# Building Code of Australia 2010 Assessment Report

## 6-16 Atchison Street, St Leonards NSW

Project No.: 10/0261

Date: 19 April 2011

TYPICAL RESIDENTIAL TYPE 1A PLAN (WITH LIFT OVERRUN)

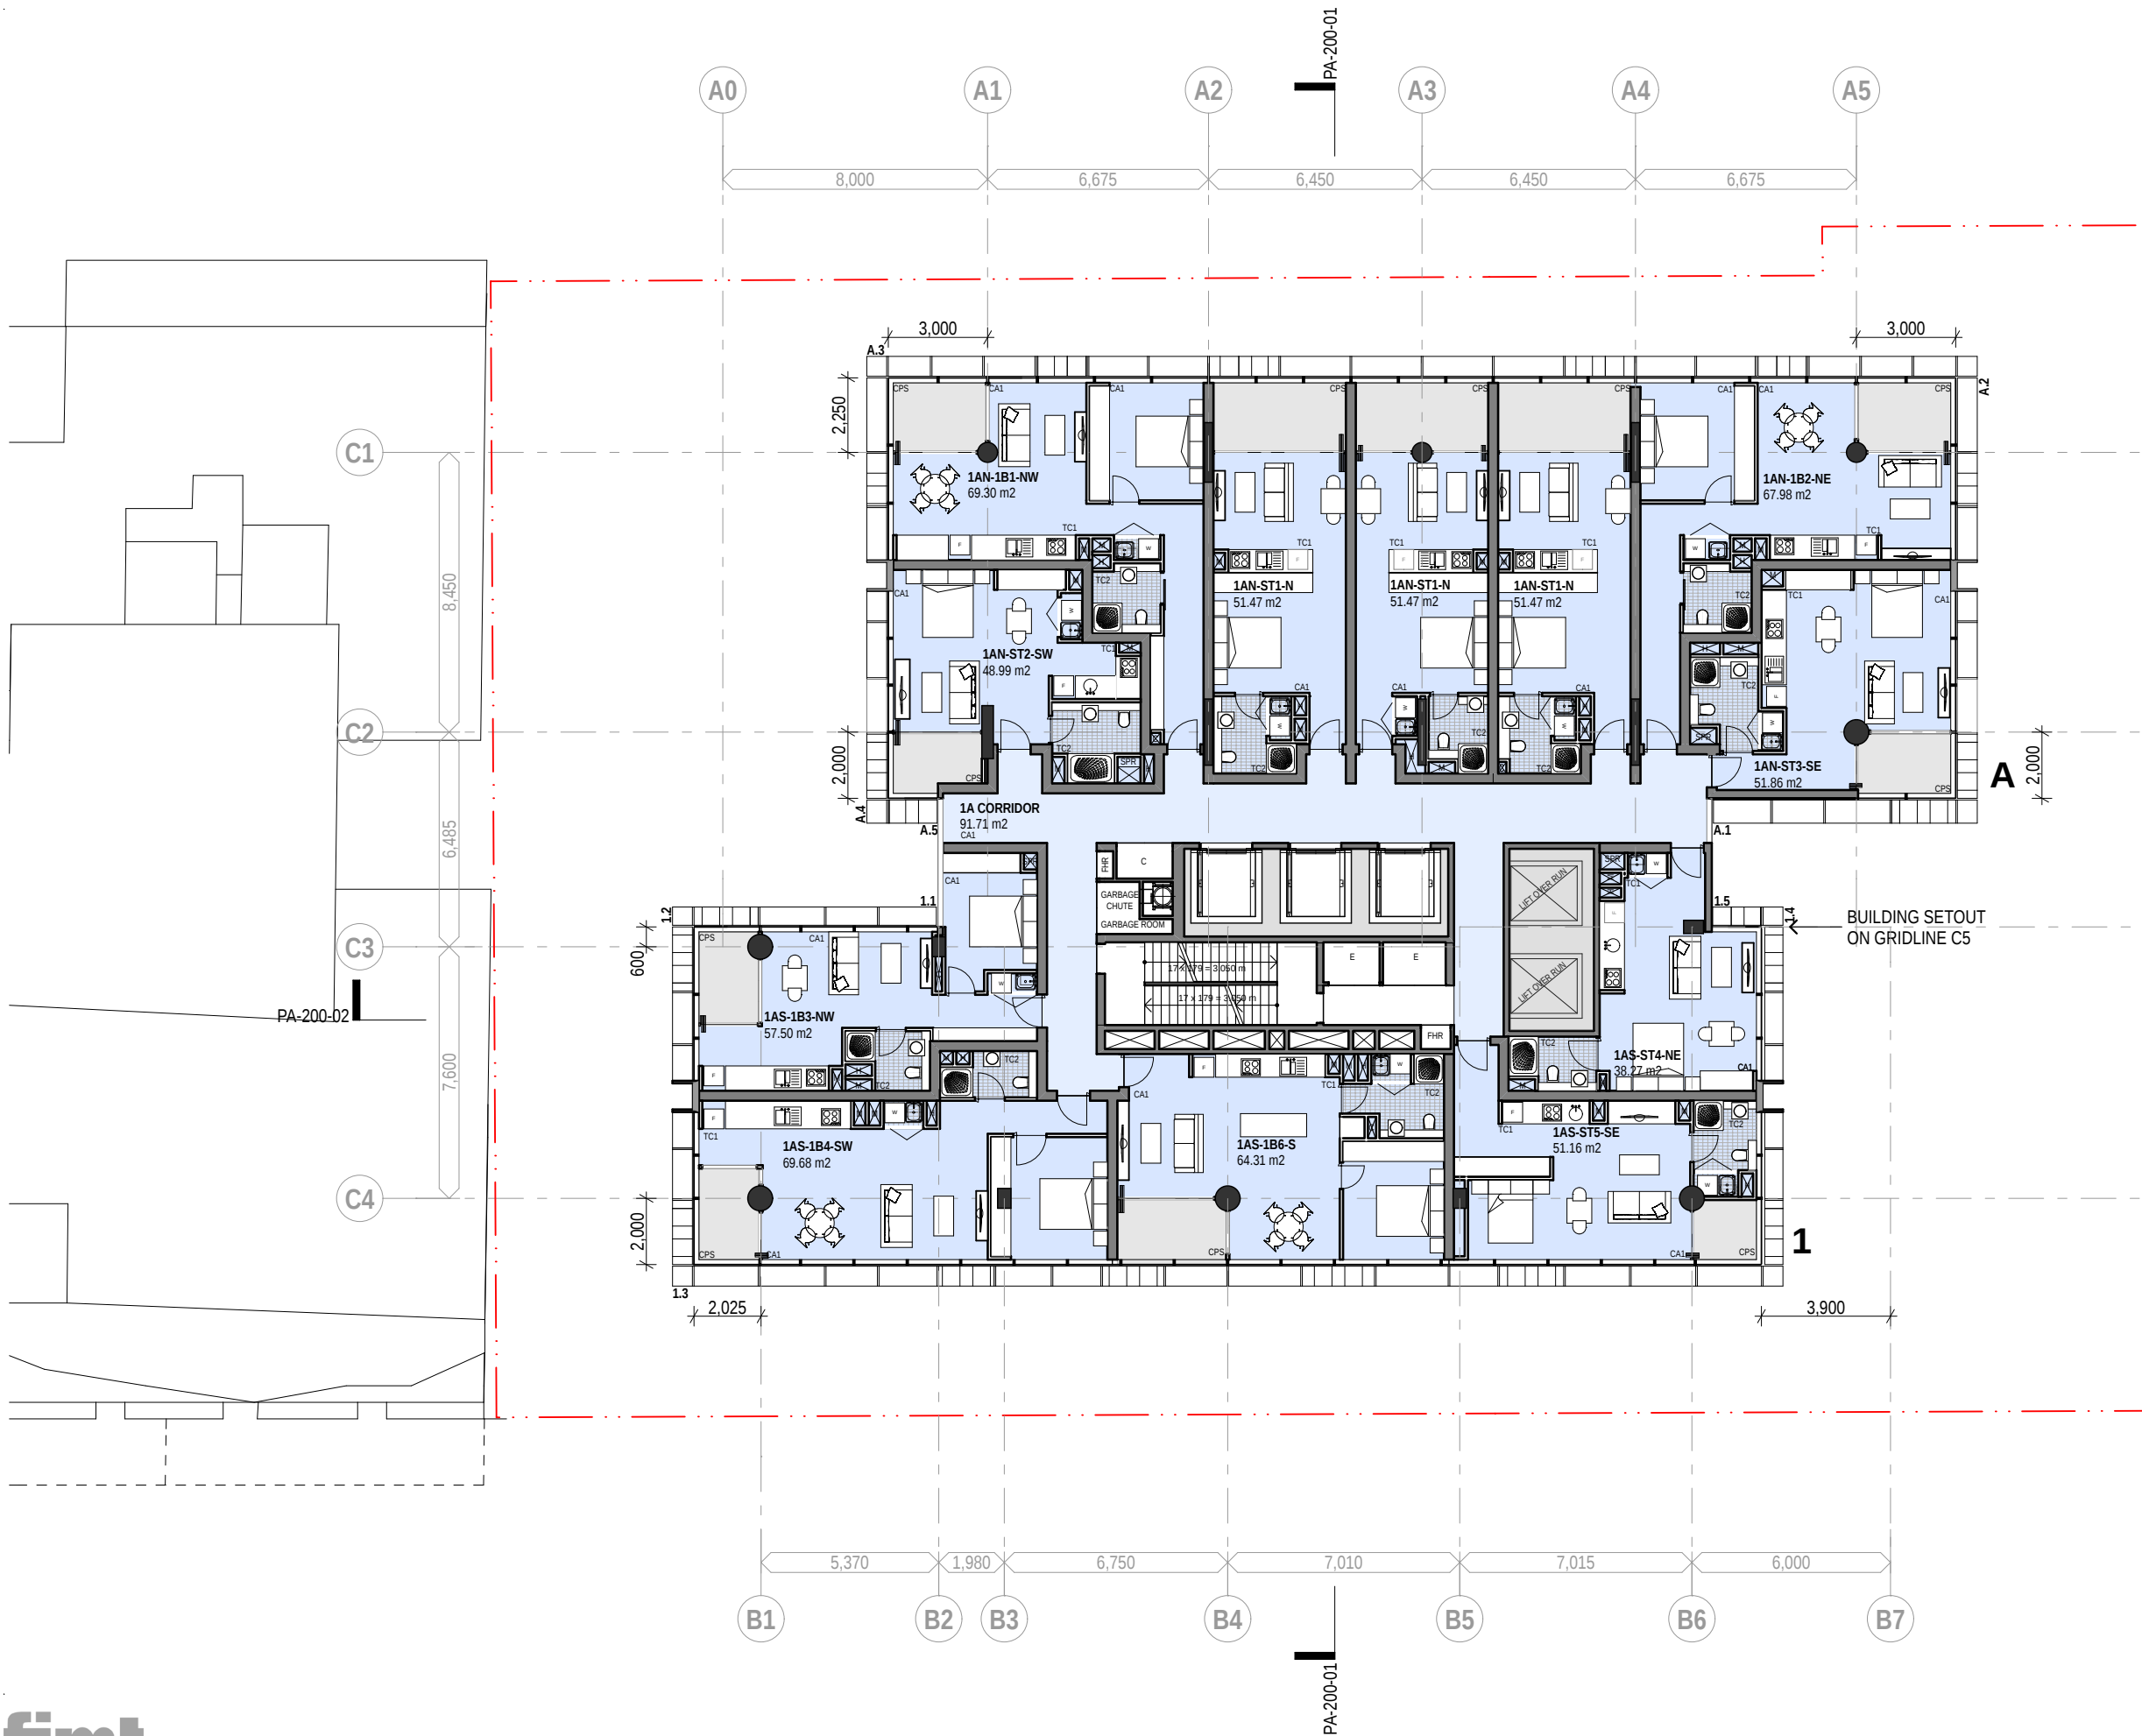
As the effective height of the building is greater than 25 metres, each storey is required to be served by a minimum of two exits, we note this provision to the building by way of a scissor stair design and have confirmed with the architect that two exits are provided at Penthouse Level 4E.
